MECKLENBURG COUNTY
Park and Recreation Department

MEMORANDUM

DATE: May 19, 2023

RE: Rezoning Petition #2023-012
PID# 14313155

REZONING
SITE PLAN

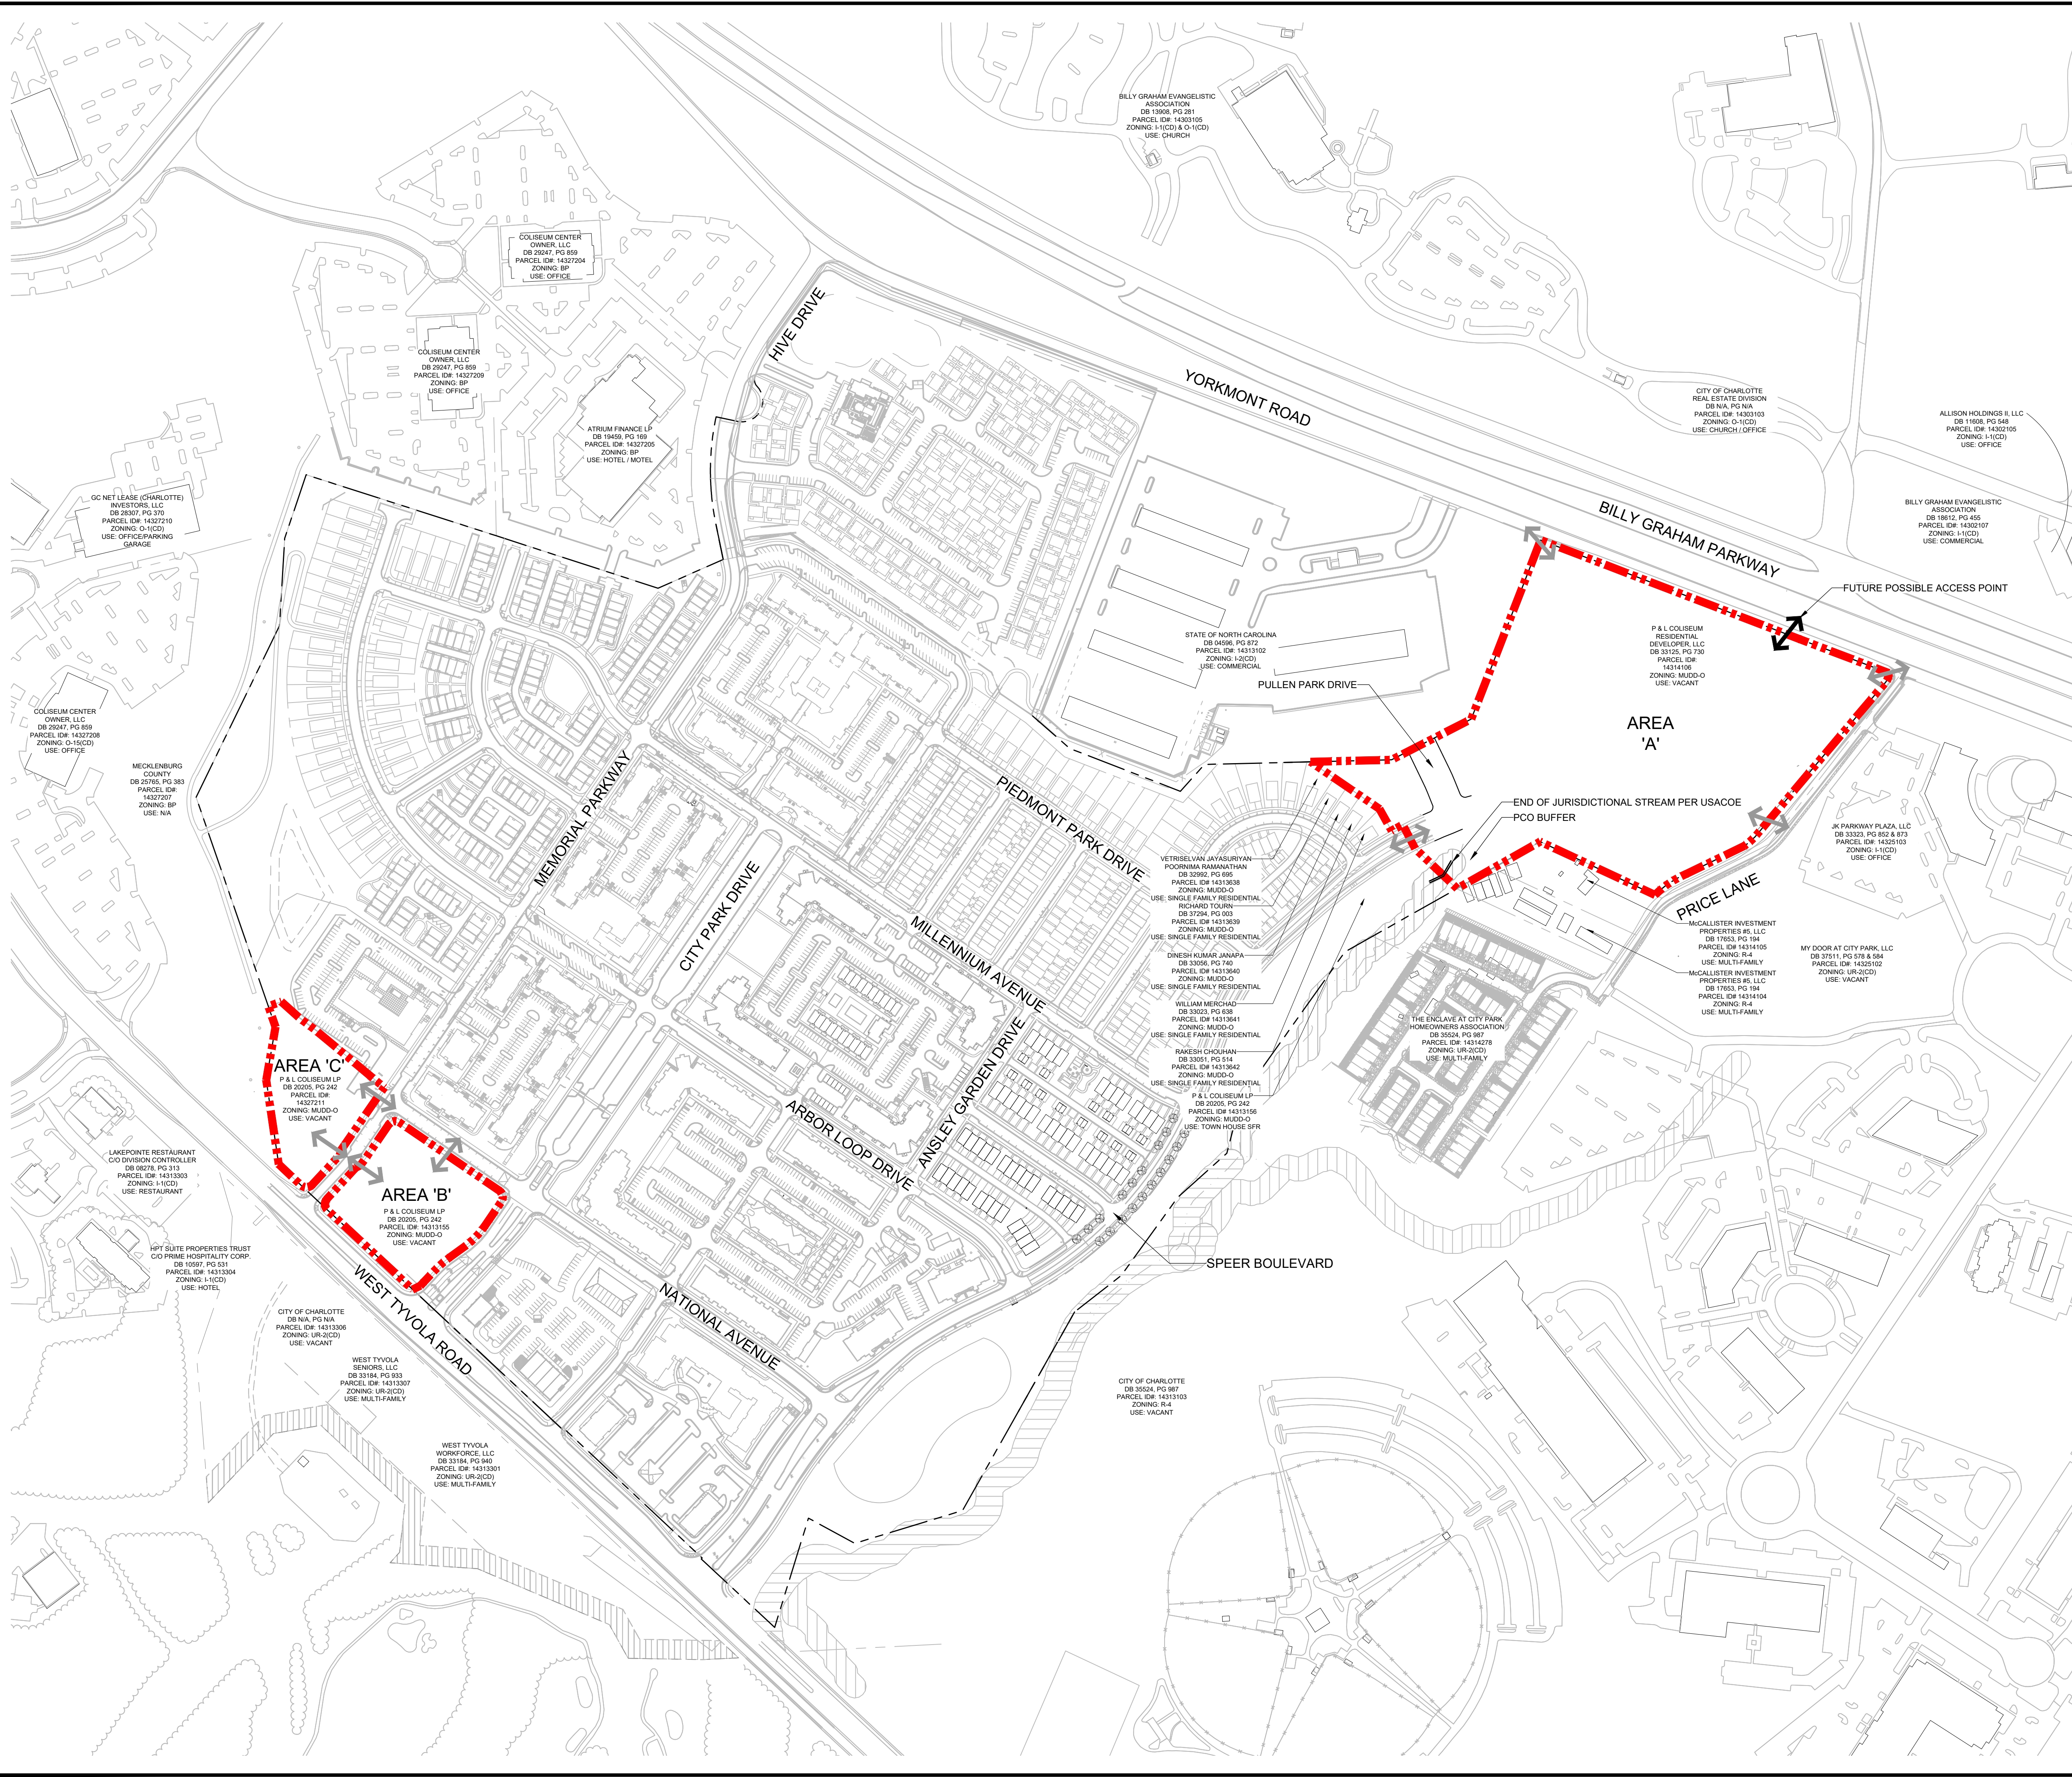
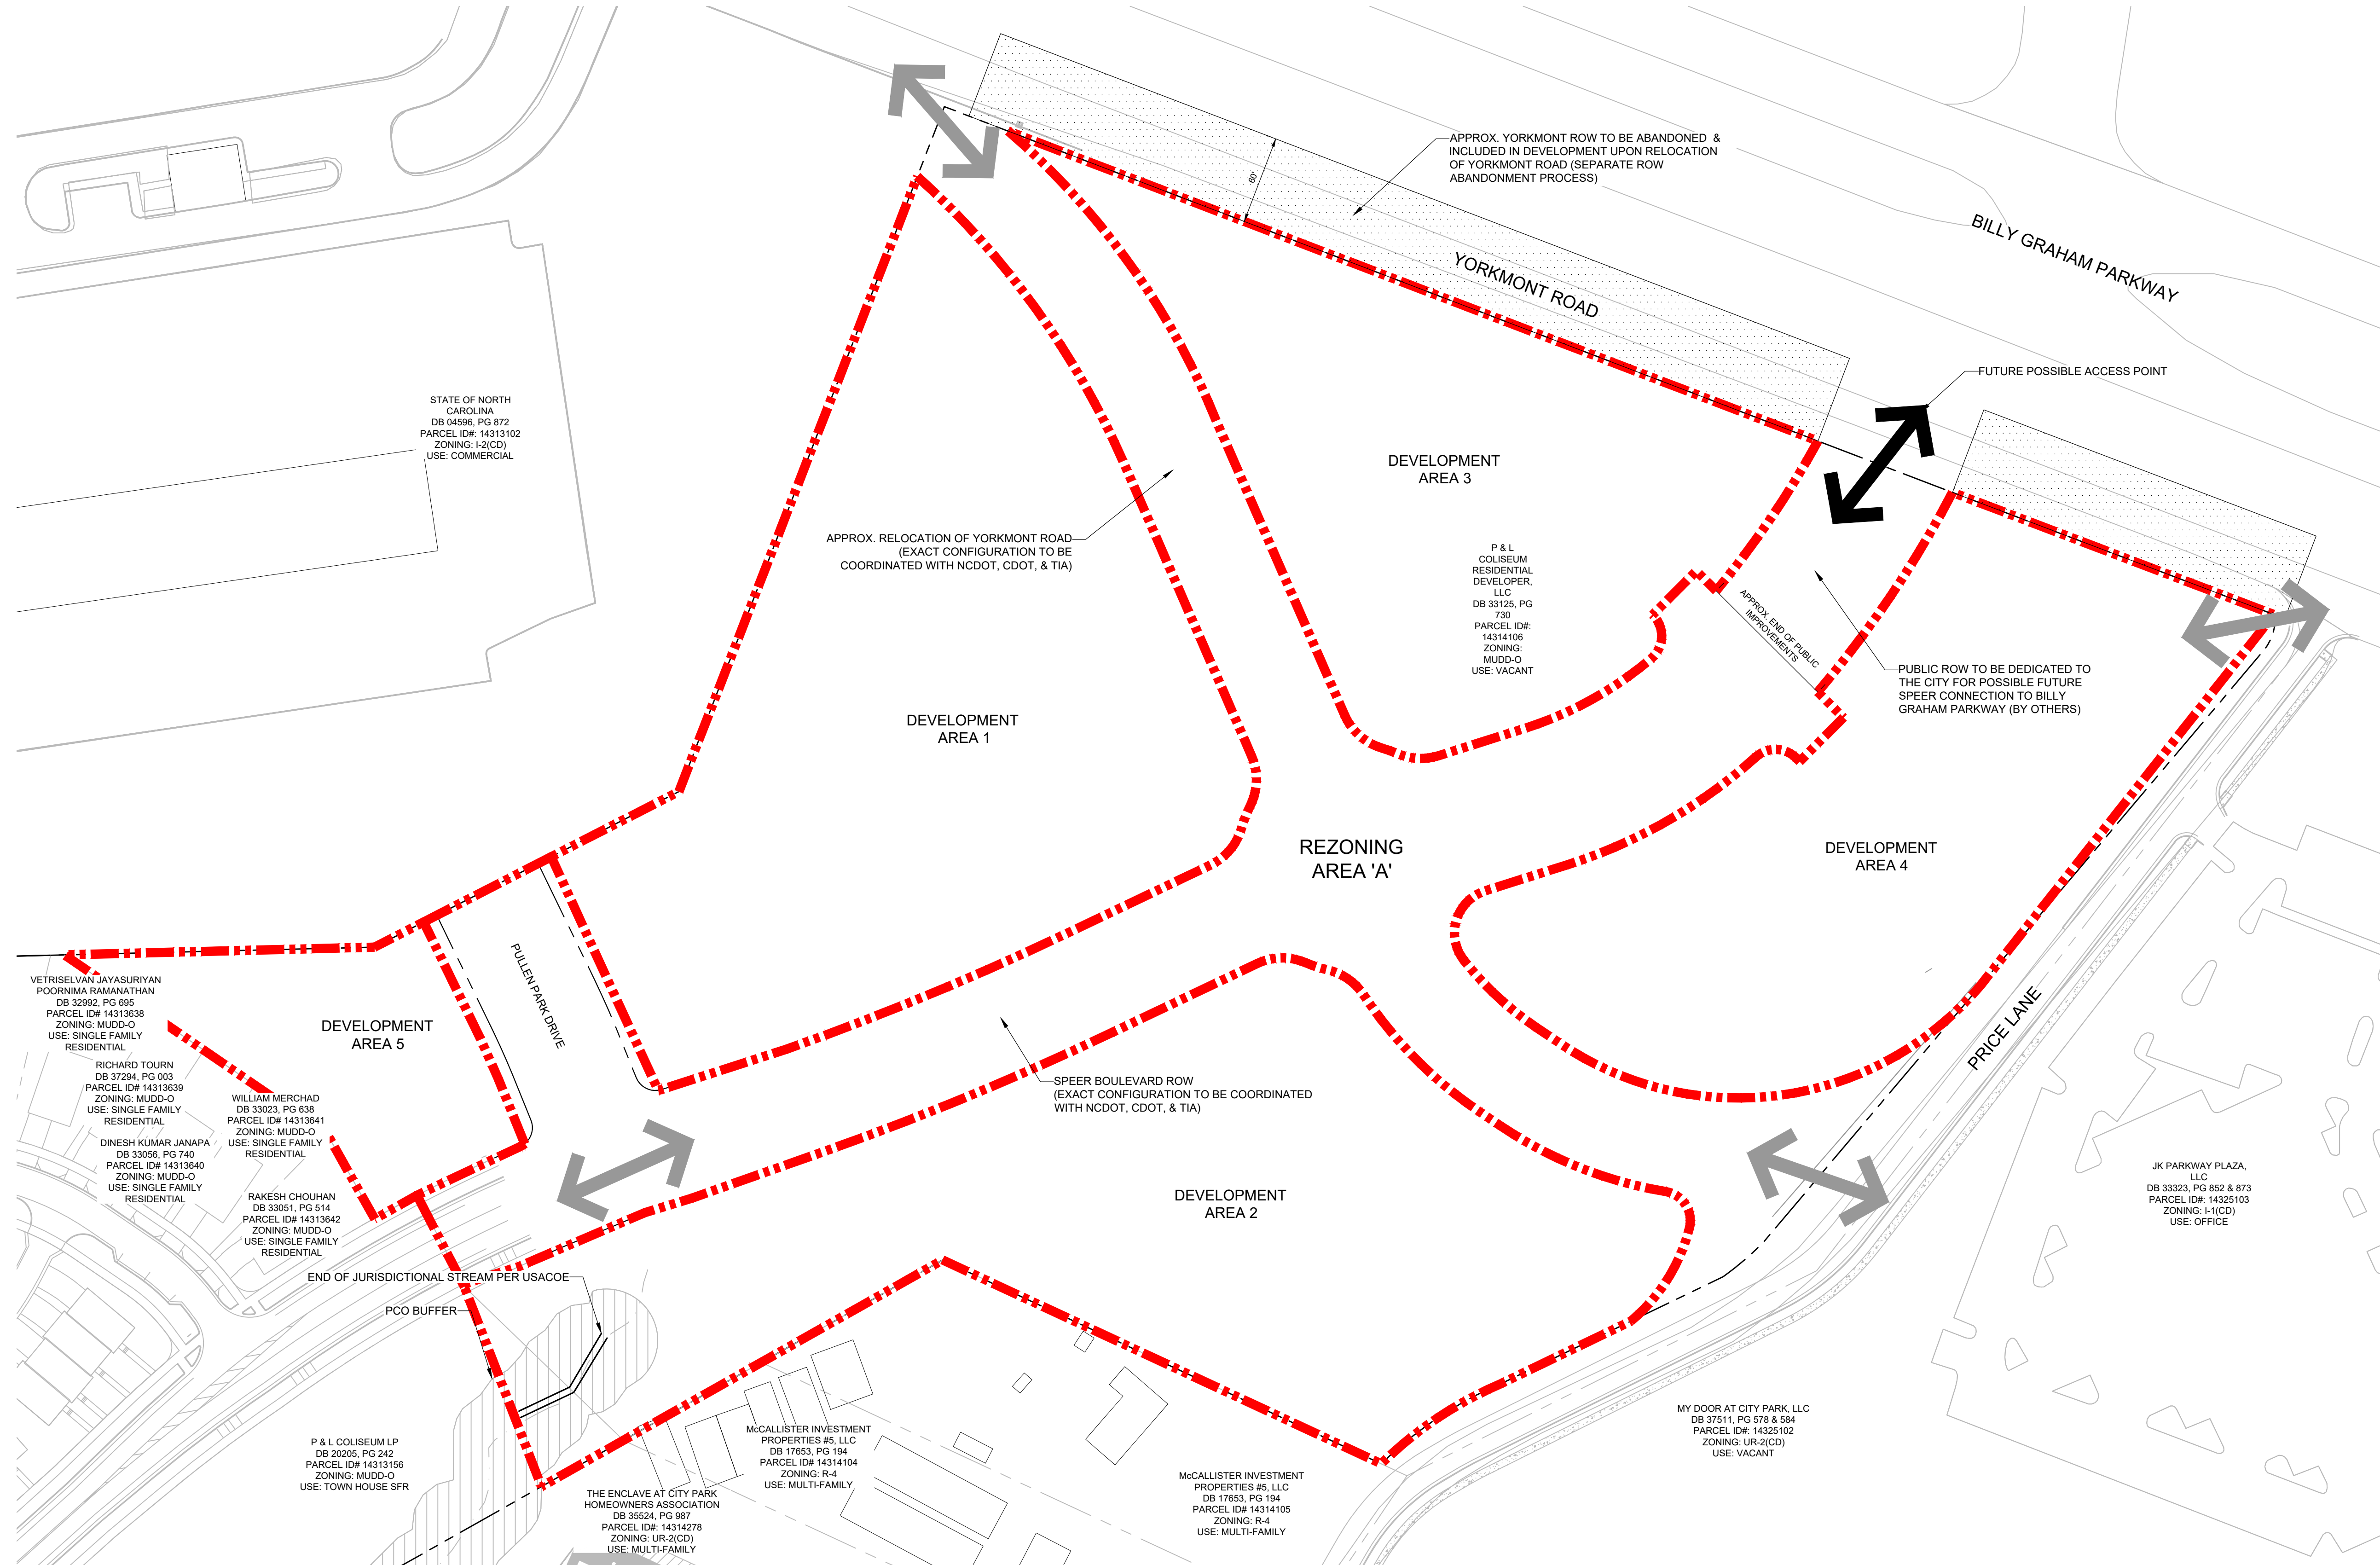
MCPR requests coordination with Mecklenburg County on access to Sugar Creek Greenway within development area "C" per the existing easement agreements.
